PLANNING AMENDMENT

APPLICANT NAME AND ADDRESS Mr & Mrs D. Robinson 57 Station Road Long Sutton Spalding PE12 9BS Telephone:	AGENT NAME AND ADDRESS JC Architectural Consultant Rose Villa Main Road Holbeach Drove Spalding PE12 0PS Telephone: 07917358101
SITE ADDRESS DETAILS As applicant details	
CURRENT APPLICATION NO: This amendment cannot be considered unless the relevant reference is stated.	H11-0177-24
Building Regulation reference relating to same development (if applicable)

Proposed Block Plan
Scale 1:500

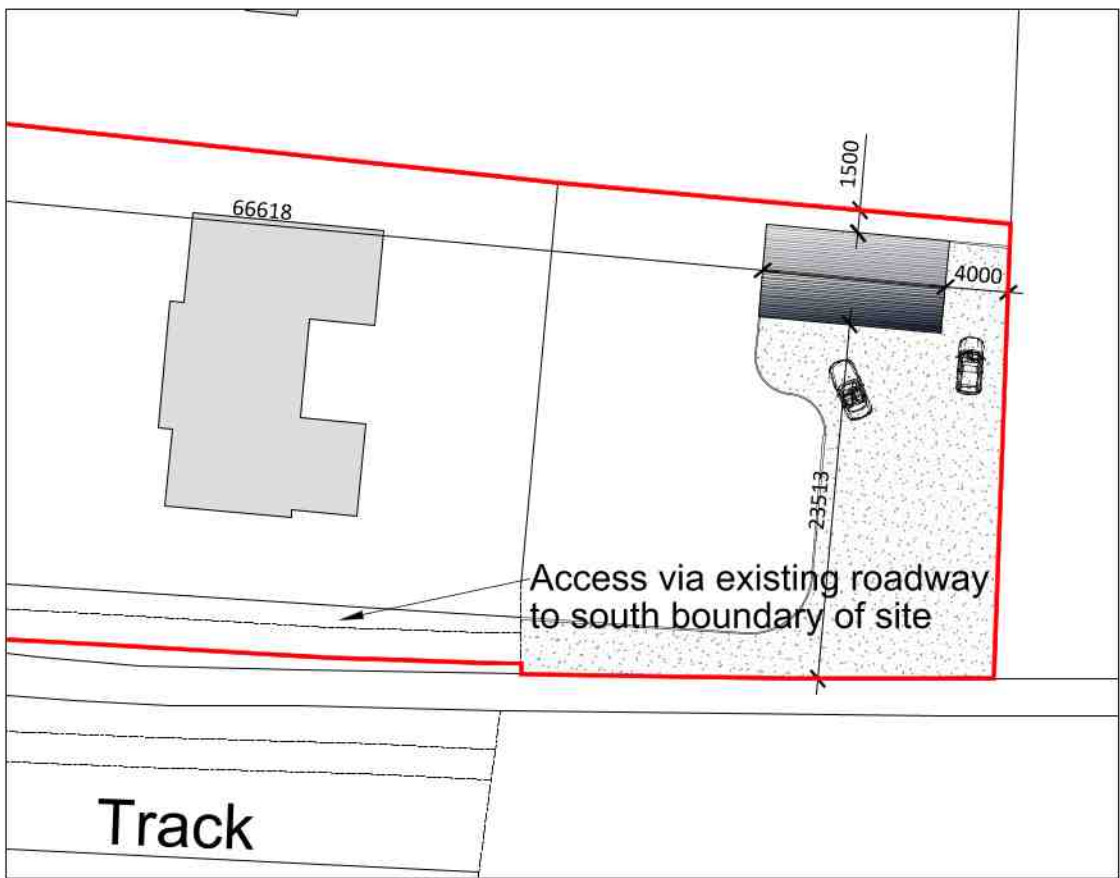
FULL DESCRIPTION OF DEVELOPMENT OF CURRENT APPLICATION THAT THIS AMENDMENT RELATES TO		
State details of amendments proposed. (Give a full detailed list of the changes, and also mark these clearly on the accompanying plans. Only the changes listed here will be considered)	Alteration to proposed block plan as requested By planning officer.	
State drawing numbers of the current submission	0440-24-01	
Has this amendment been requested by the Council? (If so, state Officer dealing with the application)	YES/NO	Yes – David Gedney
Describe any part of the original development which is excluded by virtue of the amendment, and state any alteration to plot numbers	N/A	
Has a similar amendment been submitted under Building Regulations? (If so, state Building Control Surveyor dealing with application)	YES/NO	No
